RE: REVISED DRAINAGE PLAN FOR CORONA LOOP OFFICE/WAREHOUSE  
(C-17/D1DD) ENGINEER'S STAMP DATED JULY 13, 1987

Re: Corona Loop Office/Warehouse  
City File C-17/D100

RE: DRAINAGE PLAN FOR CORONA LOOP OFFICE/WAREHOUSE  
(C-17/D1DD) RECEIVED JUNE 29, 1987

**GRADING AND DRAINAGE PLAN**

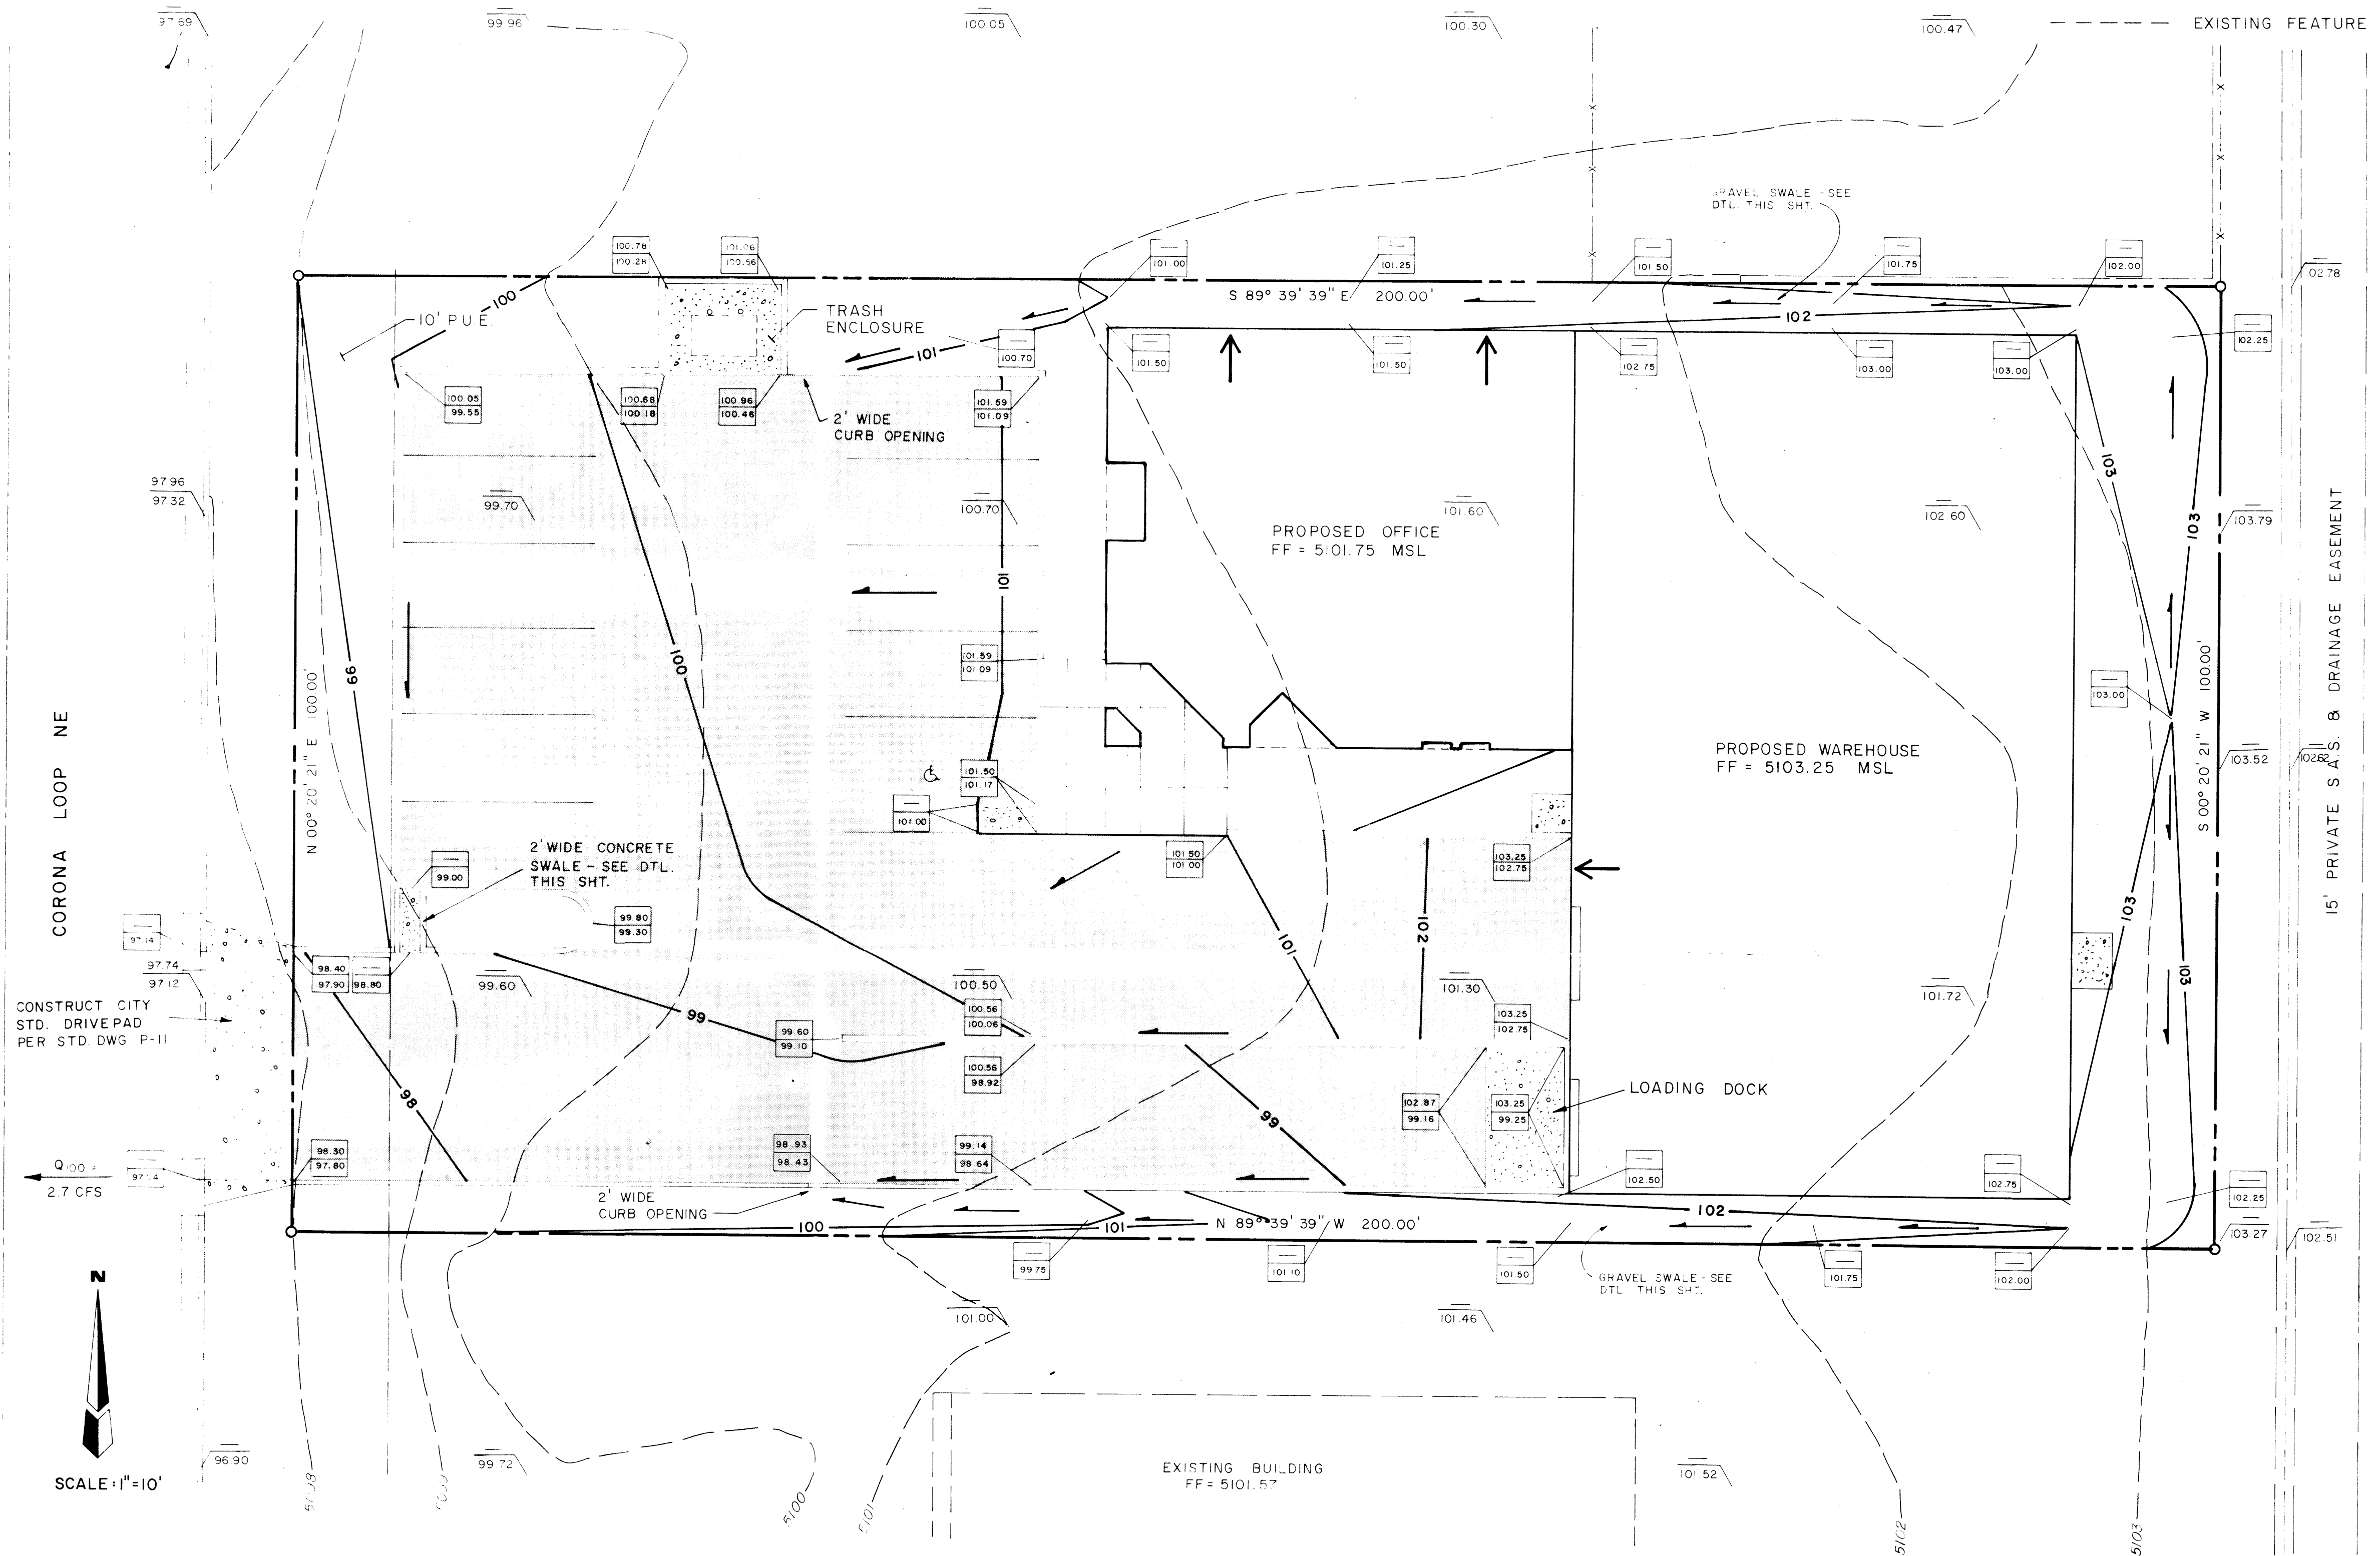
1. Please provide a typical cross-section of a swale within the dirt area so that the contractor can construct to.
2. How do you propose to get the runoff along the south property line onto the asphalt area?
3. What type of erosion control do you propose during the construction phase?
4. T.B.M. must be established on a permanent location, rebar may be destroyed during the grading process.

1. Gravel swale cross-section has been added to drawings.
2. Swale has been extended and curb opening provided.
3. Added note Number 9 addresses erosion and sedimentation control.
4. More permanent T.B.M. has been established.
